The Drovers Solar Farm

Statement of Common Ground (SoCG) with Environment Agency (Clean)

PINS reference: EN0110013

Document reference: APP/5.13.1 (Revision 1)

Drawing file: published-documents / EN0110013-000635-6.3.1 ES Figure 12.12 Drinking Water Protection Designations.pdf

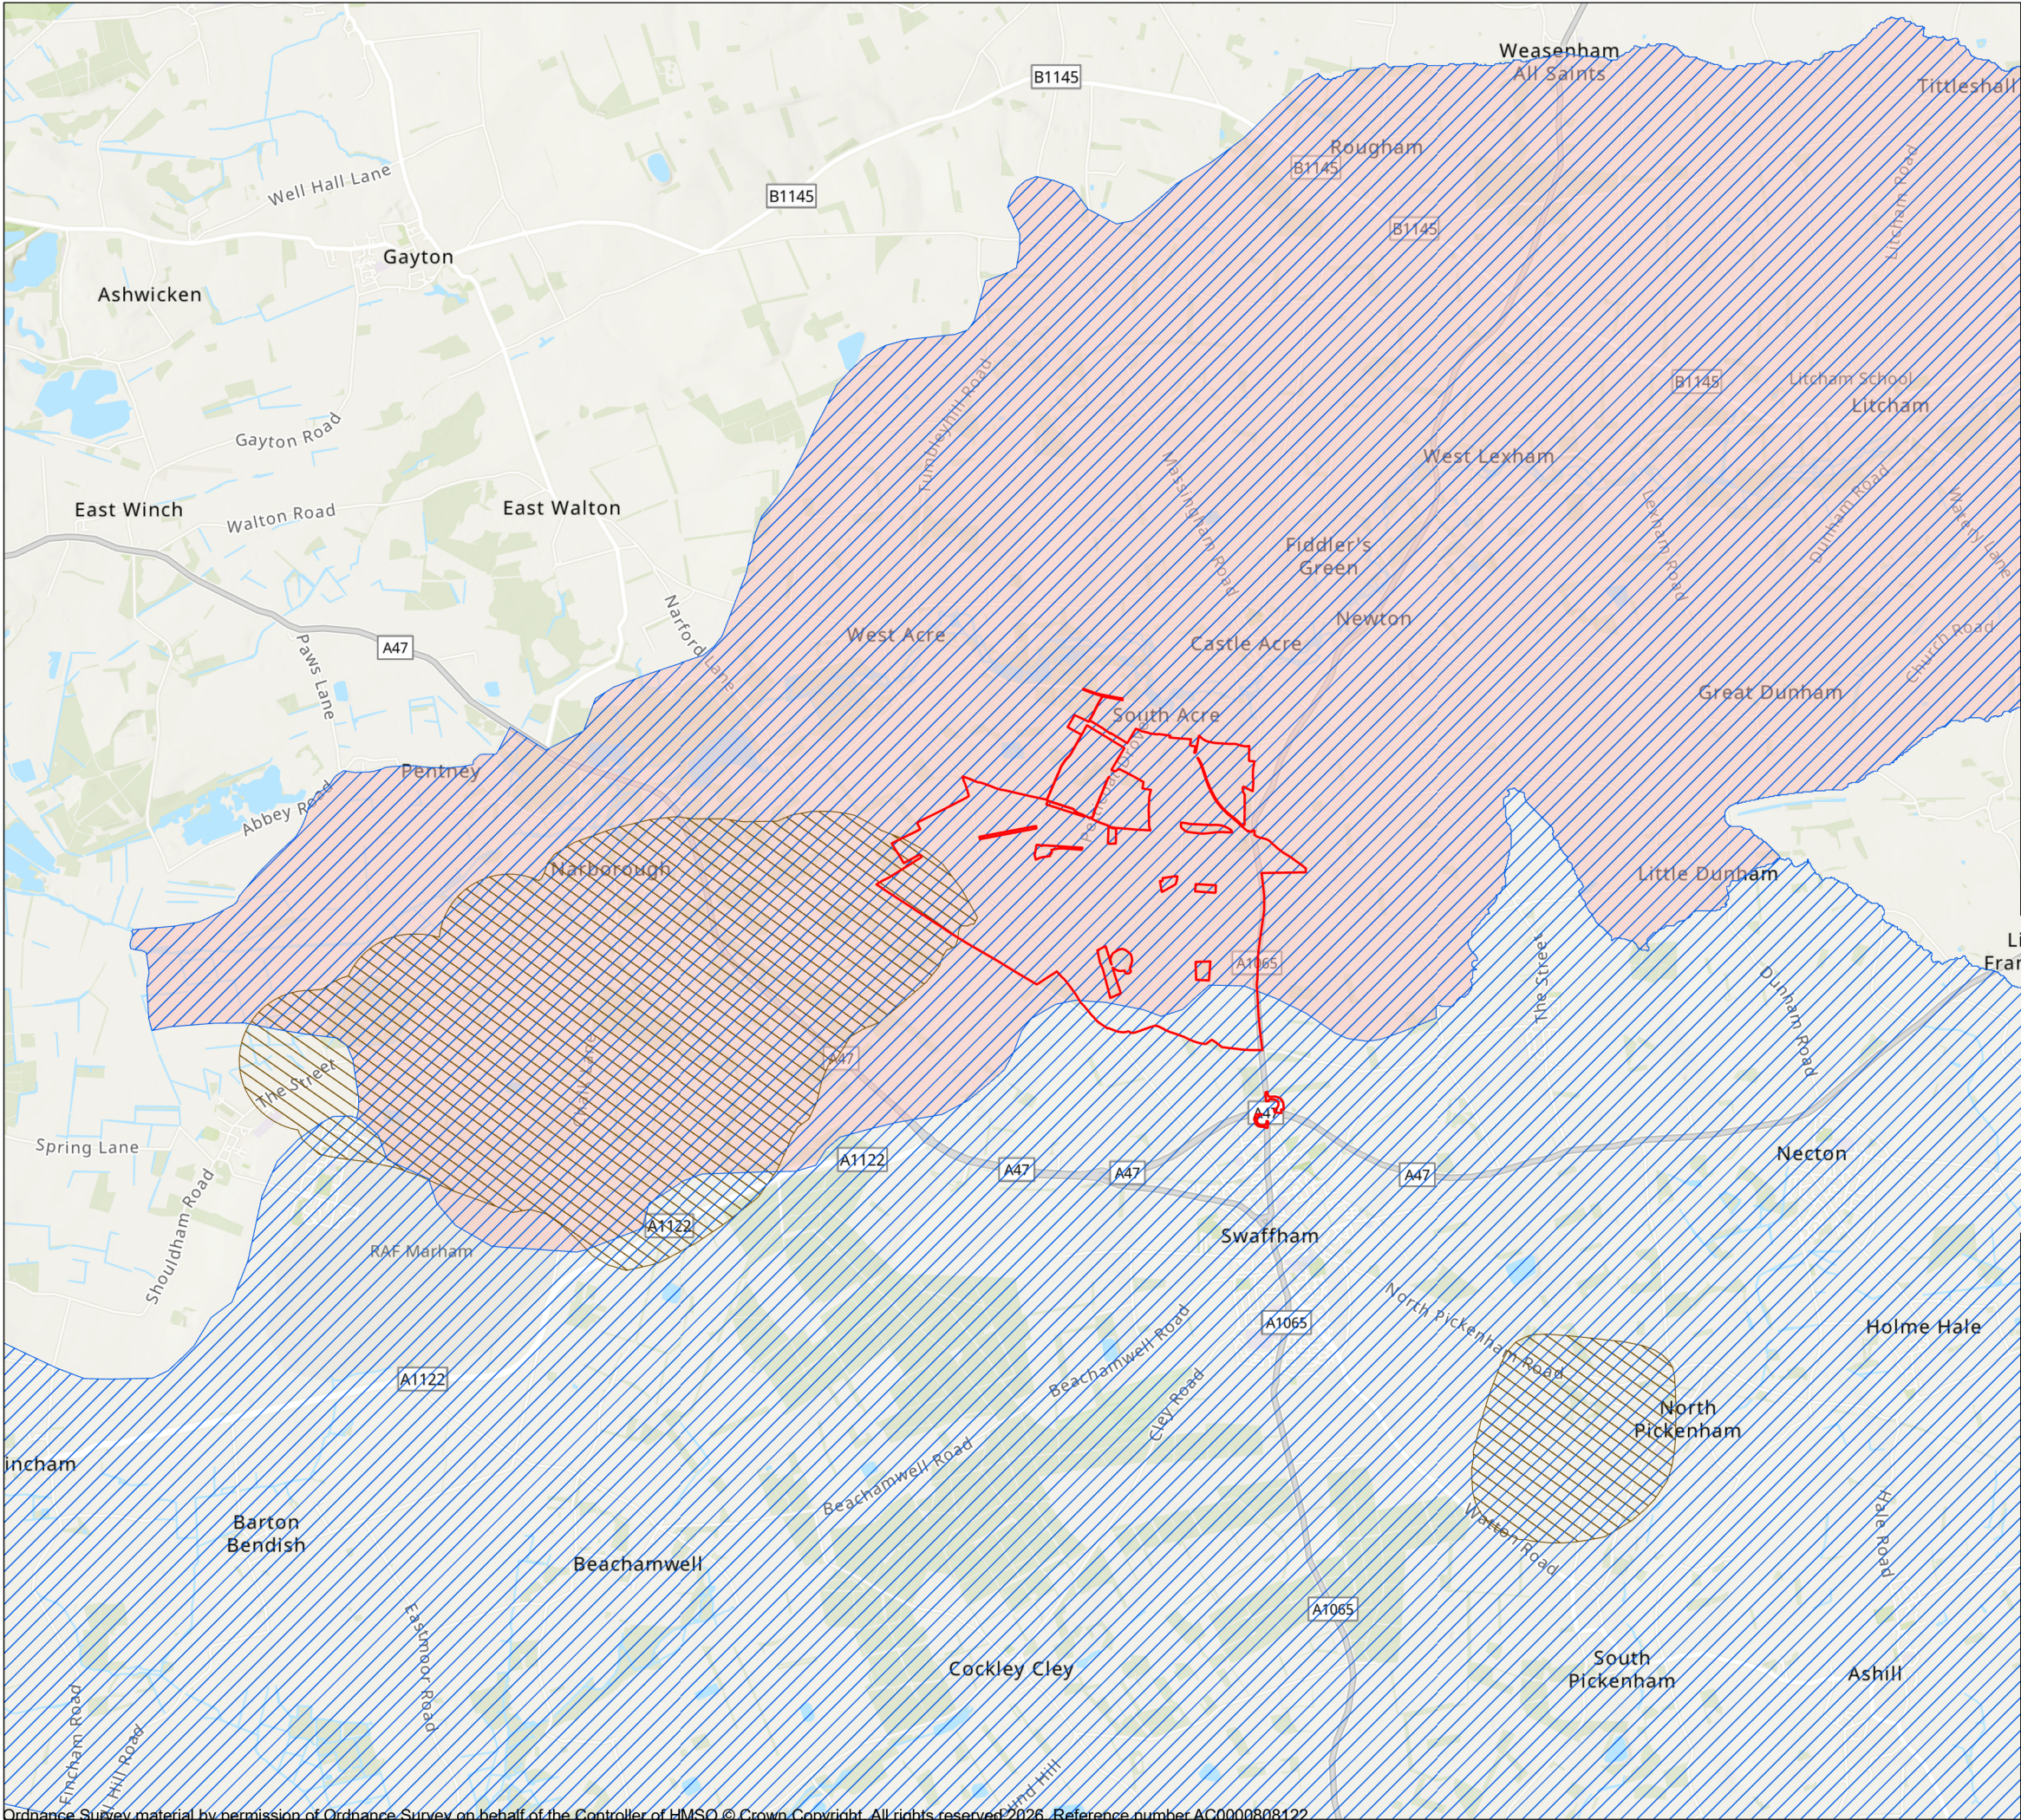
Zone lies across the entire draft Order Limits area, and how a Drinking Water Groundwater Safeguard Zone lies across the south-western part of the site. Solution: Provide figures showing other drinking water protection designations in the context of the draft Order Limits. Additional Comments:		
1-3	EA03	3D Representation of Groundwater	Figure 12.7 3D Representation of Groundwater [APP-121] Figure 12.8 Minimum Static Groundwater Level Depths within CSA [APP-122] Figure 12.9 Maximum Static Groundwater Level Depths within CSA [APP-123] Issue: Figure 12.7 is poorly executed. Impact: Figure 12.7 is difficult to interpret which limits its value. It is difficult to distinguish the site topography, relative elevation of groundwater, extents of the hydrogeological model, viewpoint orientation and relation to the study site. Groundwater elevation appears to be a single plane uninfluenced by surface elevation in the context of the model. Solution: Revise Figure 12.7 to provide additional views of the modelled area, with clearer indication of view orientation and	To aid the Environment Agency's interpretation of ES Figure 12.7: 3D Representation of Groundwater [APP/6.3.1], the following changes have been made at Deadline 3. • Addition of orientation labels or description • Elevation shading to show mAOD values for the maximum groundwater elevation surface and foundation extent surface; and • Figures and text refer to groundwater elevation (mAOD) rather than groundwater level to increase clarity between absolute elevation and depth below ground.	Low

Reference	EA Issue Reference	Topic	Consultee's Position	Applicant's Position	Status
1-1	EA01	Source Protection Zone	Figure 12.5: Source Protection Zone [APP-119] Issue: Figure 12.5 is not easily interpreted due to shading not being used to define Source Protection Zone (SPZ) extents. Impact: Unclear to the reader how the draft Order Limits, Battery Energy Storage System (BESS) sites, substation sites and SPZs intersect. Solution: Update Figure 12.5 to use shading to clearly define SPZ extents. Additional Comments:	ES Figure 12.5: Source Protection Zone [APP/6.3.1] was intended to show what infrastructure is located within SPZ 1 and 2; however, to aid the Environment Agency's interpretation, this Figure has been updated at a Deadline 3.	Low
1-2	EA02	Drinking Water Protected Area	Figure 12.12 Drinking Water Protected Area [APP-126] Issue: Figure 12.12 shows the extents of a designated Drinking Water Protected Area in the context of the site, but there are no figures showing other drinking water protection designations. Impact: The reader is unable to see how the Drinking Water Surface Water Safeguard	It is noted that ES Figure 12.12: Drinking Water Protected Area [APP-126] does not show other drinking water protection designations and this Figure has been updated at Deadline 3 ES Figure 12.12: Drinking Water Protection Designations [APP/6.3.1].	Low
